DELEGATED HOUSEHOLDER DECISION

Item No. Report of the Head of Planning, Sport and Green Spaces**Address** 106 THORNTON AVENUE WEST DRAYTON**Development:** Single storey rear extension**LBH Ref Nos:** 71145/APP/2015/3208**Drawing Nos:** Design and Access Statement
7975/P/201
7975/P/202
7975/P/203**Date Plans Received:** 24/08/2015**Date(s) of Amendment(s):****Date Application Valid:** 24/08/2015**1. CONSIDERATIONS****1.1 Site and Locality**

No.	DESCRIPTION	DATE
Drawing Title EXISTING & PROPOSED ELEVATIONS		
Drawing No.		
7975	P	203

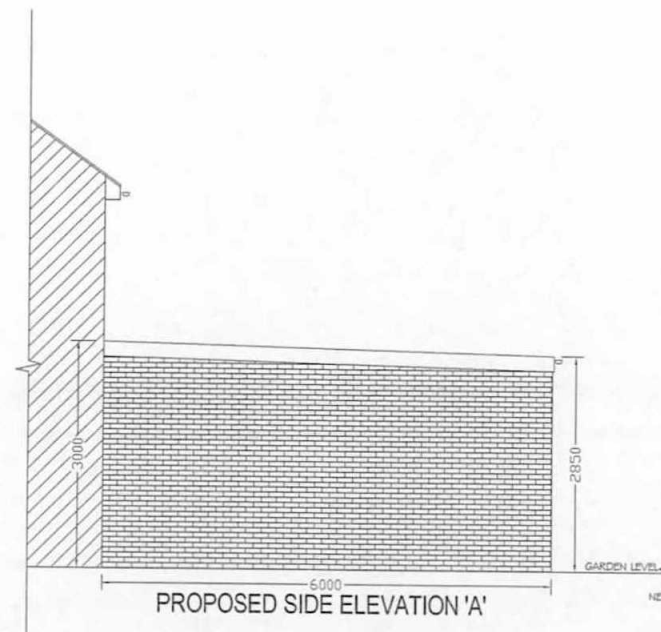
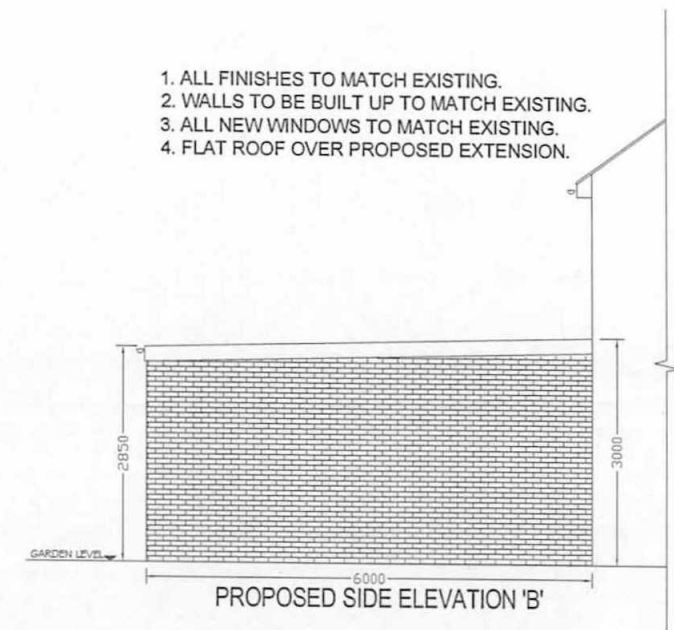
Paragraph 3.3 of HDAS:EXT limits the distance of a single storey rear extension to a terraced houses to 3.6m to prevent loss of light and outlook of neighbouring properties. The proposed development would extend the rear of the property to 6m and as such exceeds the guidance by a considerable amount.

There are no rear extensions to either neighbouring properties, and given the north-south orientation of the properties, 104 Thornton Avenue being the northern of the two, the proposed extension would have a detrimental impact on the adjoining neighbour due to its size and scale, resulting in overshadowing, loss of sunlight/daylight and loss of outlook. Due to its scale and juxtaposition to ground floor windows of the adjoining house, the proposed extension would result in visual intrusion and spoil the outlook from the property, and be over dominant.

The neighbouring property No.108 Thornton Avenue is set back behind the rear elevation of the application property, therefore the impact of the proposed extension on this property would be perhaps more ameliorate. However, at 6m the scale of the extension would still impinge upon rear ward views from the neighbouring dwelling and spoil the outlook from that property.

The proposed extension is out of scale and disproportionate to what is a modest sized terraced house. It would not be subservient to the host dwelling or the neighbouring properties and would be detrimental to the appearance of the dwellings.

The proposed extension, by virtue of its size, scale, bulk, depth and proximity, would be detrimental to the amenities of the adjoining occupier at 104 Thornton Avenue by reason of overdominance, overshadowing, visual intrusion, loss of light and loss of outlook. Therefore the proposal would be contrary to policies BE19, BE20 and BE21 of the Hillingdon Local Plan: Part Two - Saved UDP Policies (November 2012) and the Council's adopted Supplementary Planning Document HDAS: Residential Extensions.

The proposed extension, by virtue of its siting, size, scale, bulk and excessive depth, would fail to appear as a subordinate addition and would thus be detrimental to the appearance of the original house and the visual amenities, character and appearance of the wider area. The proposal is therefore contrary to Policy BE1 of the Hillingdon Local Plan: Part One - Strategic Policies (November 2012), Policies BE13, BE15 and BE19 of the Hillingdon Local Plan: Part Two - Saved UDP Policies (November 2012) and the adopted Supplementary Planning Document HDAS: Residential Extensions.
